Re: VR-18-011 Resubmittal

Please see below responseS to El Paso County's comments regarding the submittal for file VR-18-011.

REPLAT OF LOTS 1-4, CLAREMONT RANCH FILING NO. 9B
IN THE NORTHWEST QUARTER OF SECTION 4, T14S, R66W OF THE 6TH P.M.
COUNTY OF EL PASO, STATE OF COLORADO

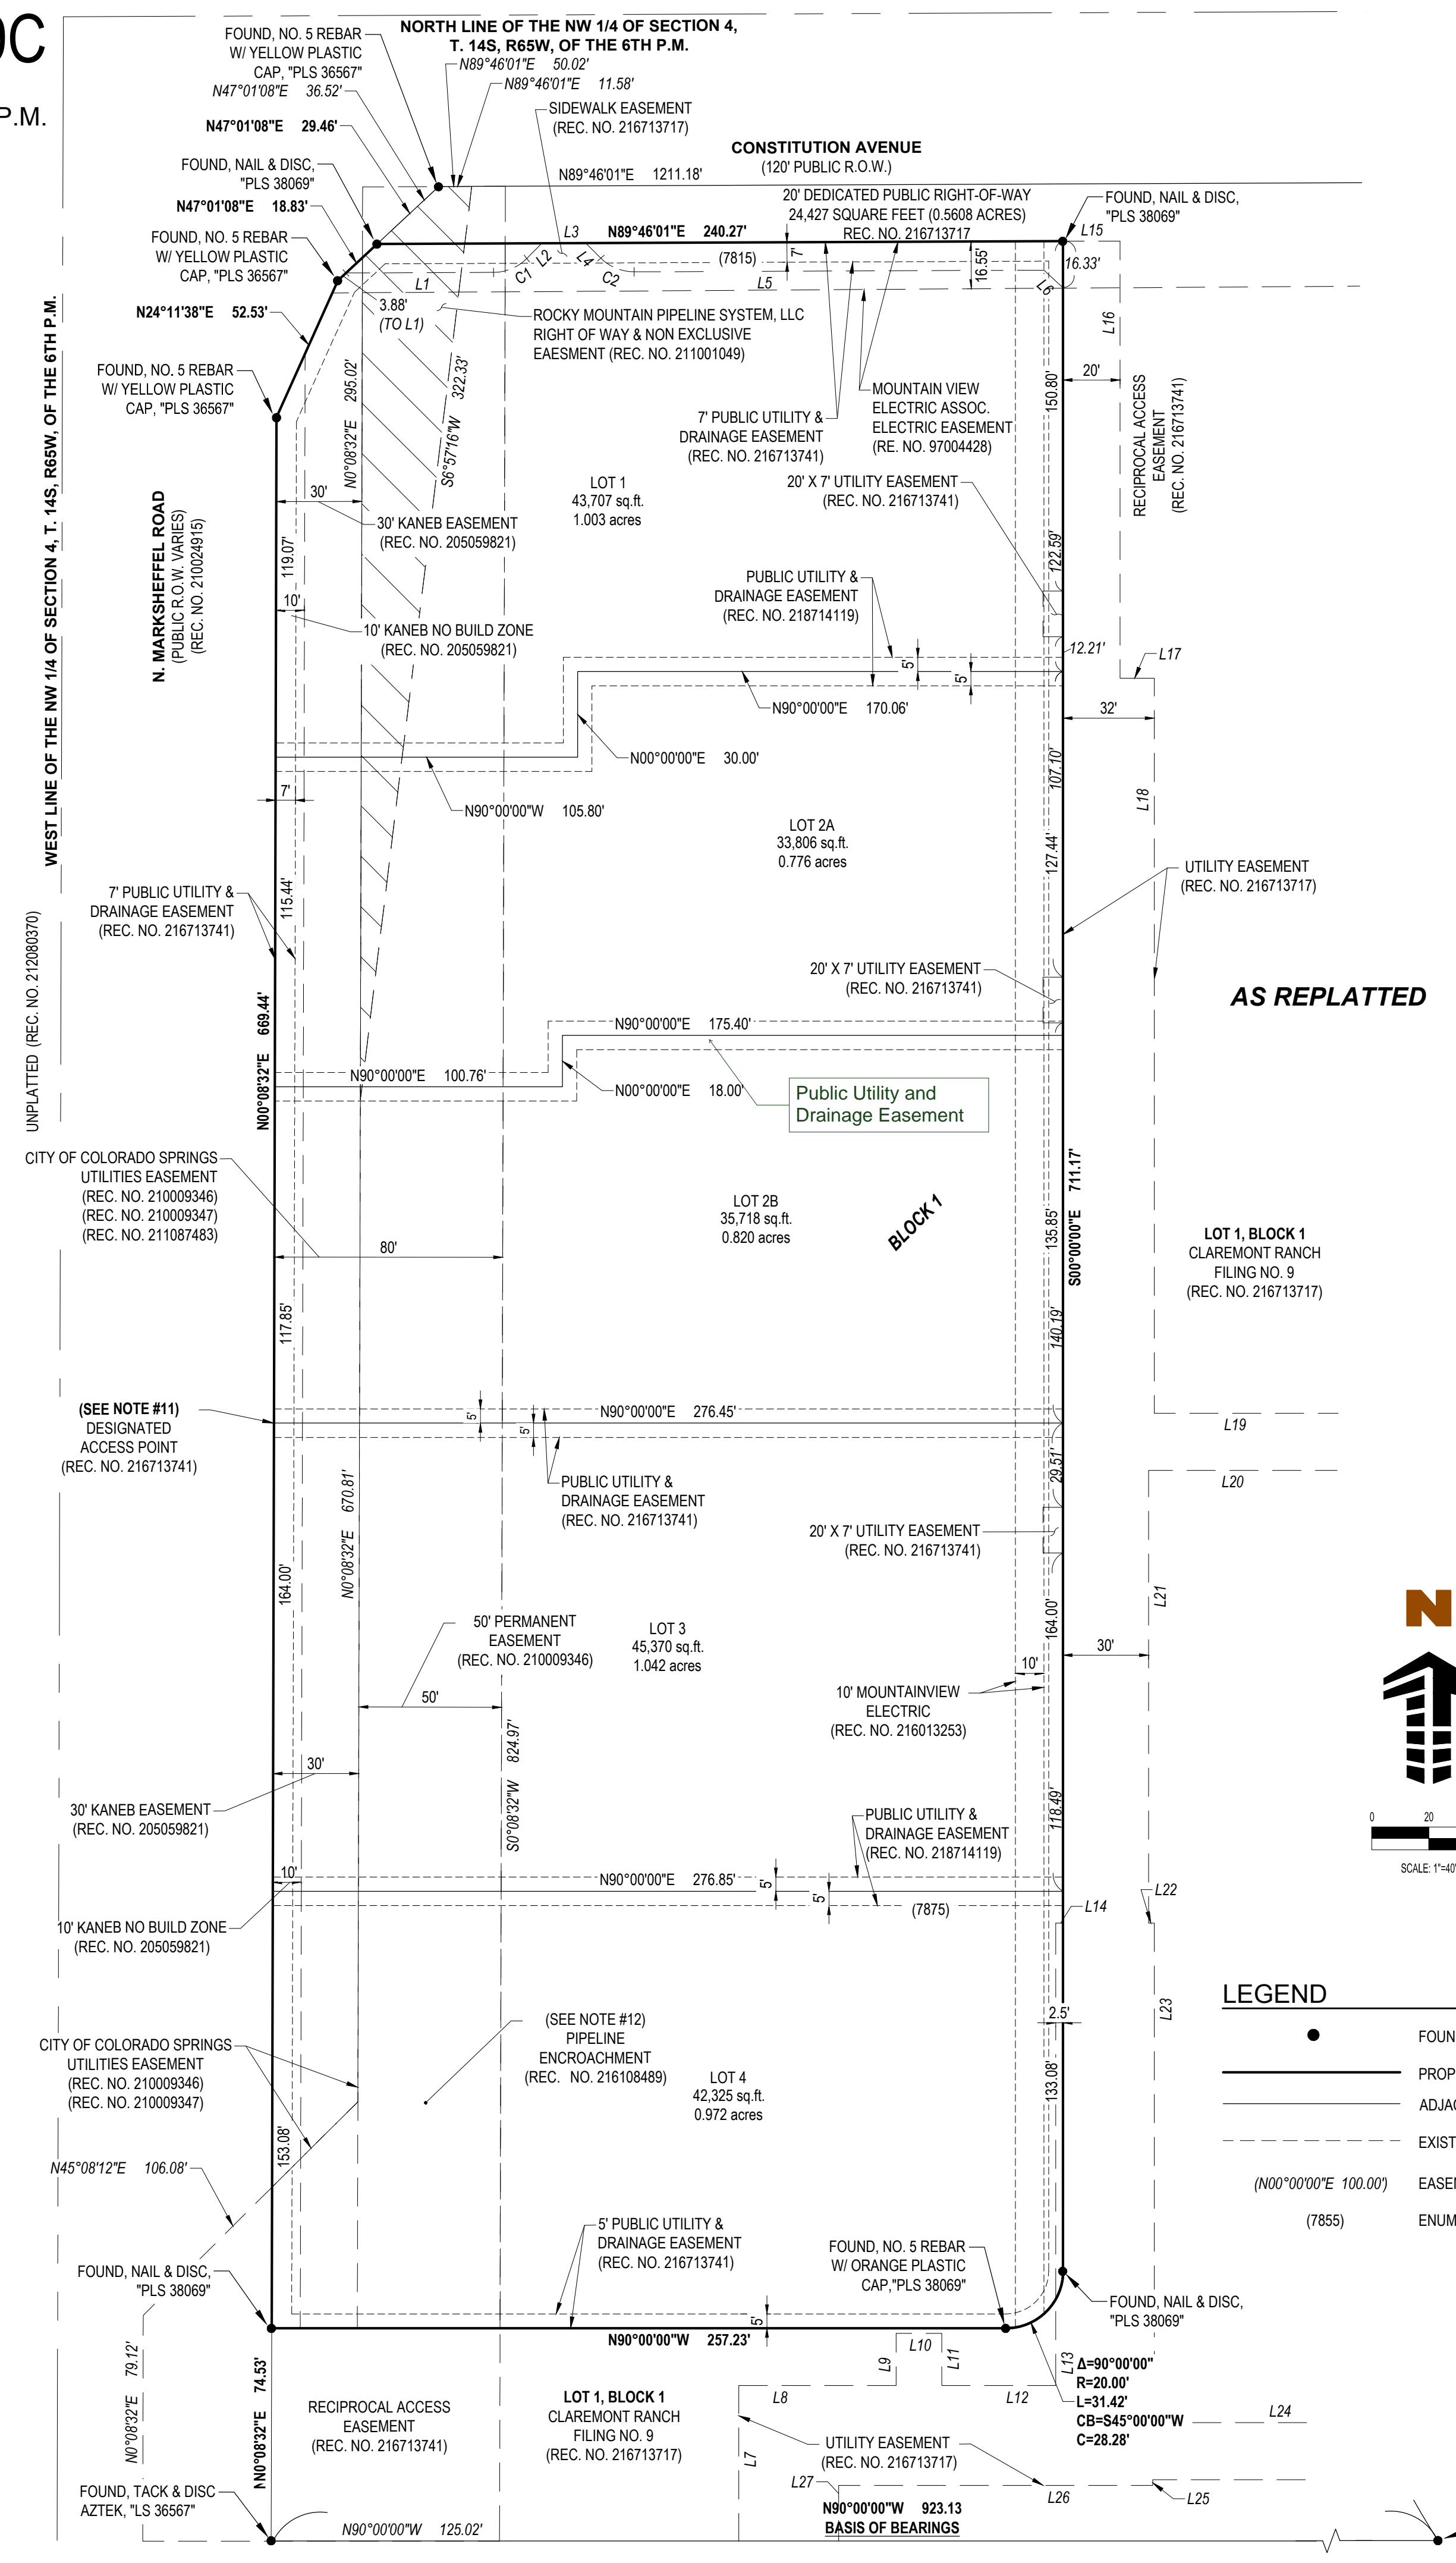
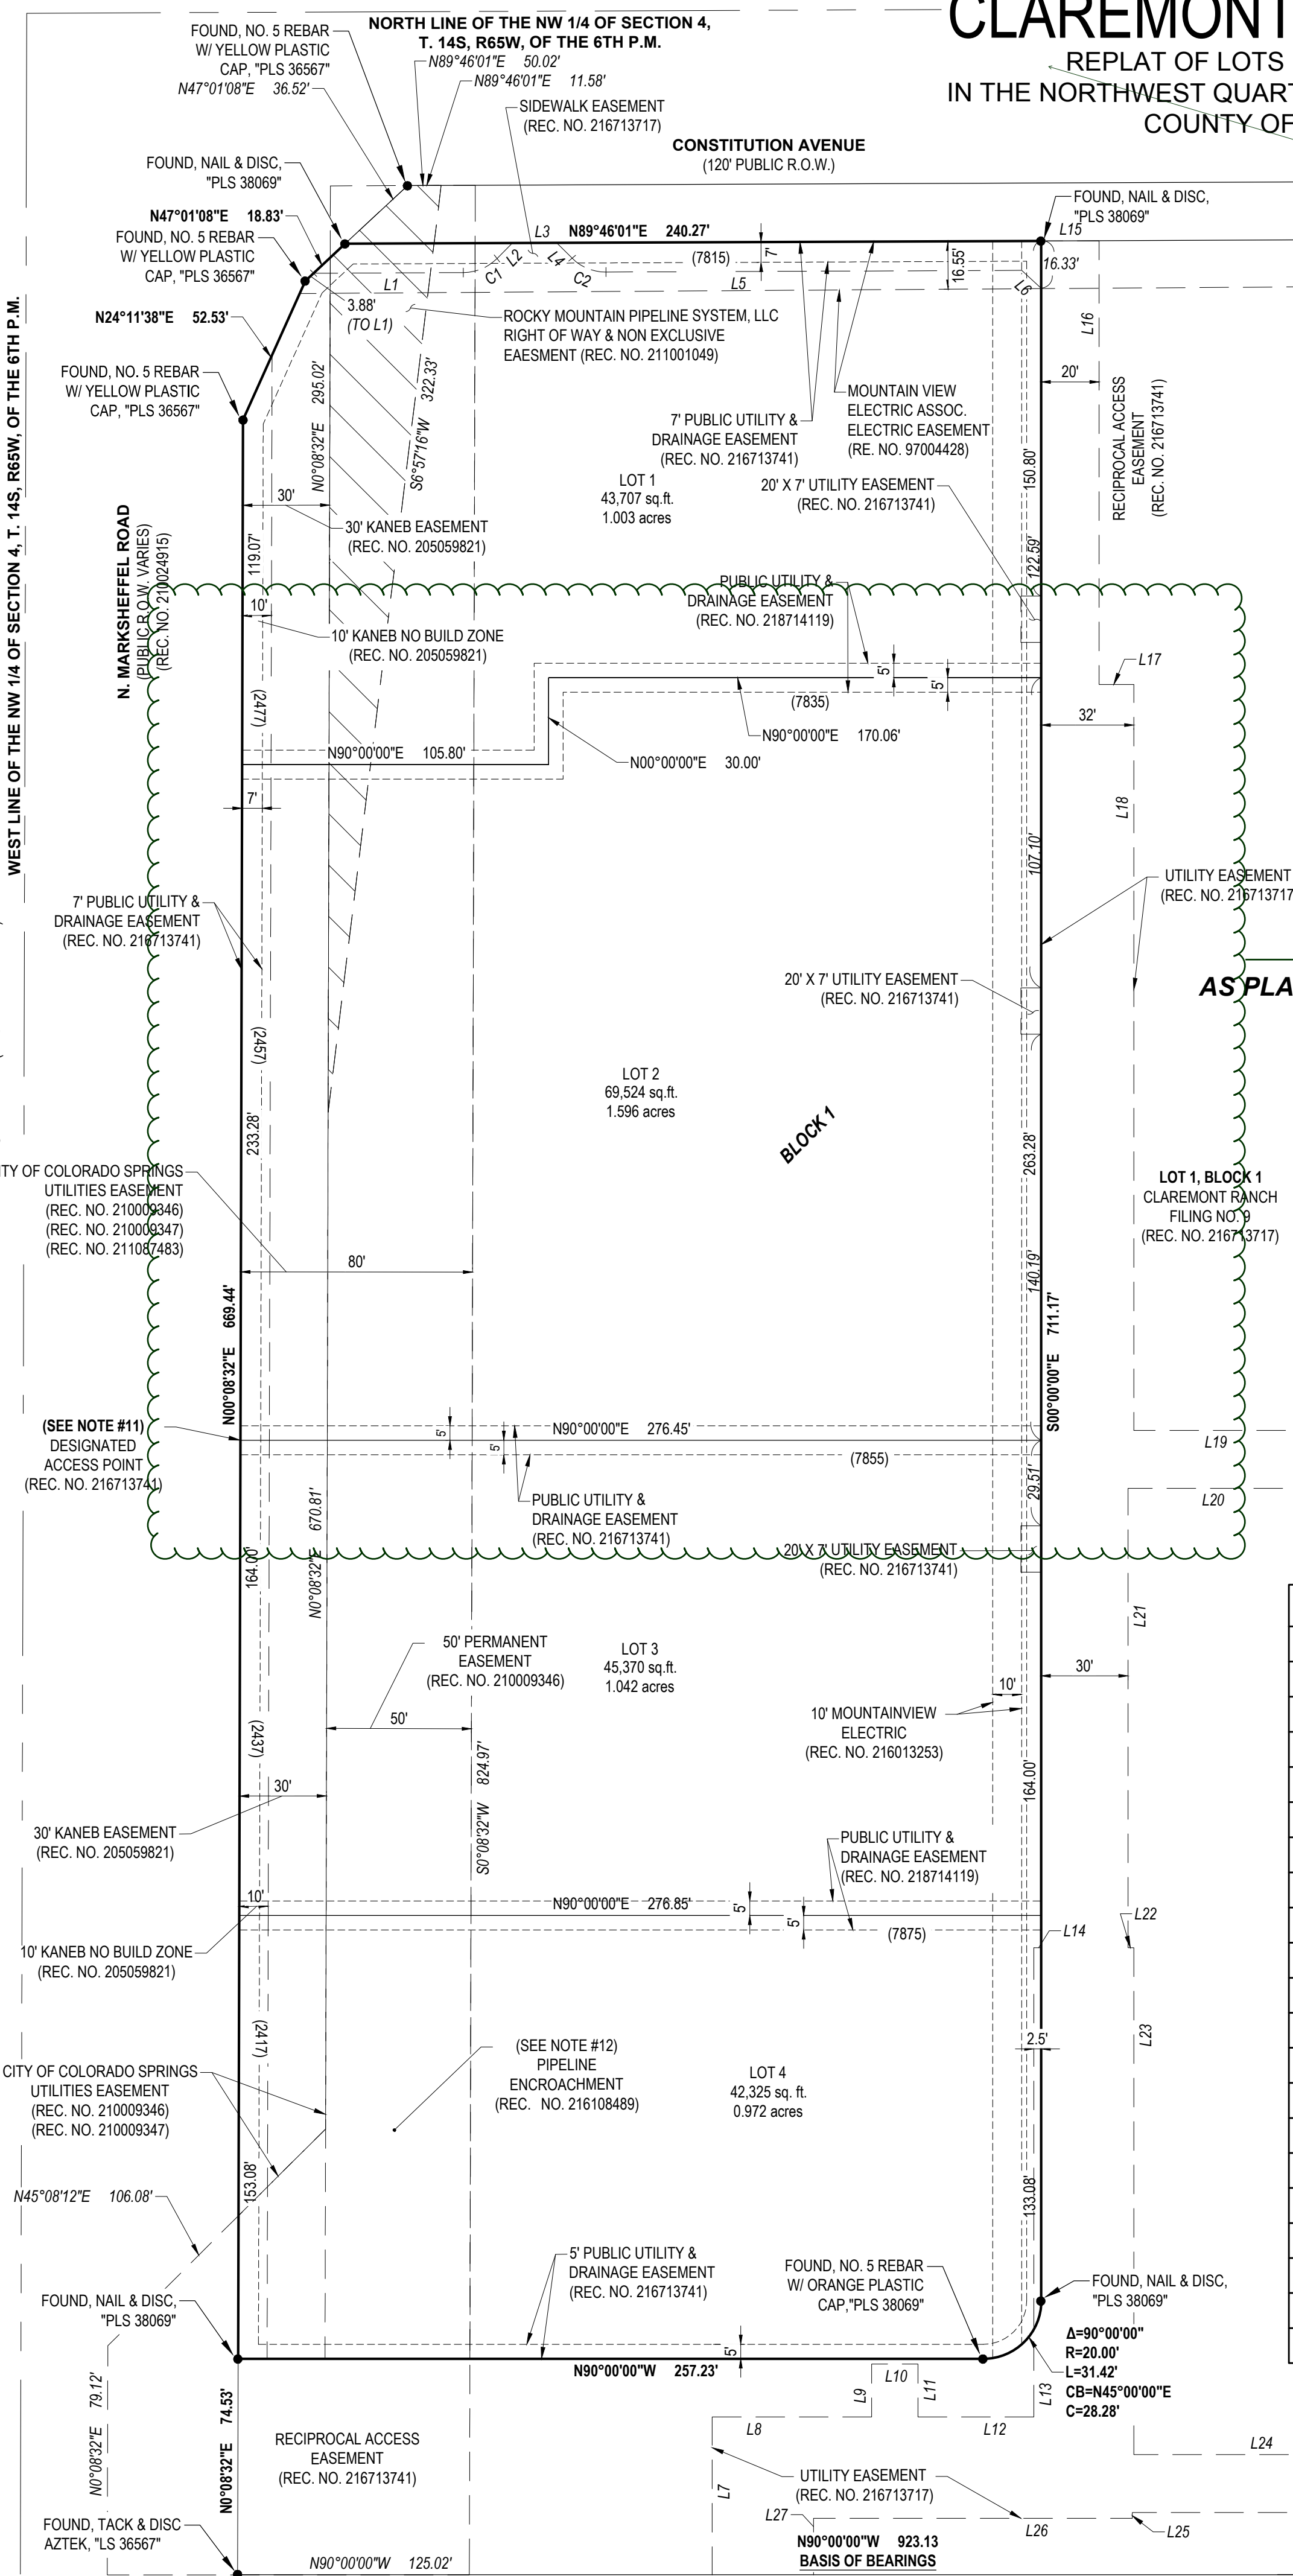
Regarding a request for approval of a final plat for Claremont Ranch Filing No. 9C, Enumerations has the following comments: **1)** Per Regional Building Code section RBC312.8, addresses must appear on plats. The address for lots 1, 3 and 4 should appear on the plat as they are currently addressed. Lot 2B should show the address which is currently assigned for Lot 2 of Claremont Ranch Filing No. 9B which is 2457 N. Marksheffel Rd. Lot 2A should show the address of 2467 N. Marksheffel Rd. **2)** The range shown in the title block of this plat is incorrect. This parcel is in Range 65. **3)** Standard final plat comments apply. The

*RESPONSE: Revised survey includes addresses and corrected range.*
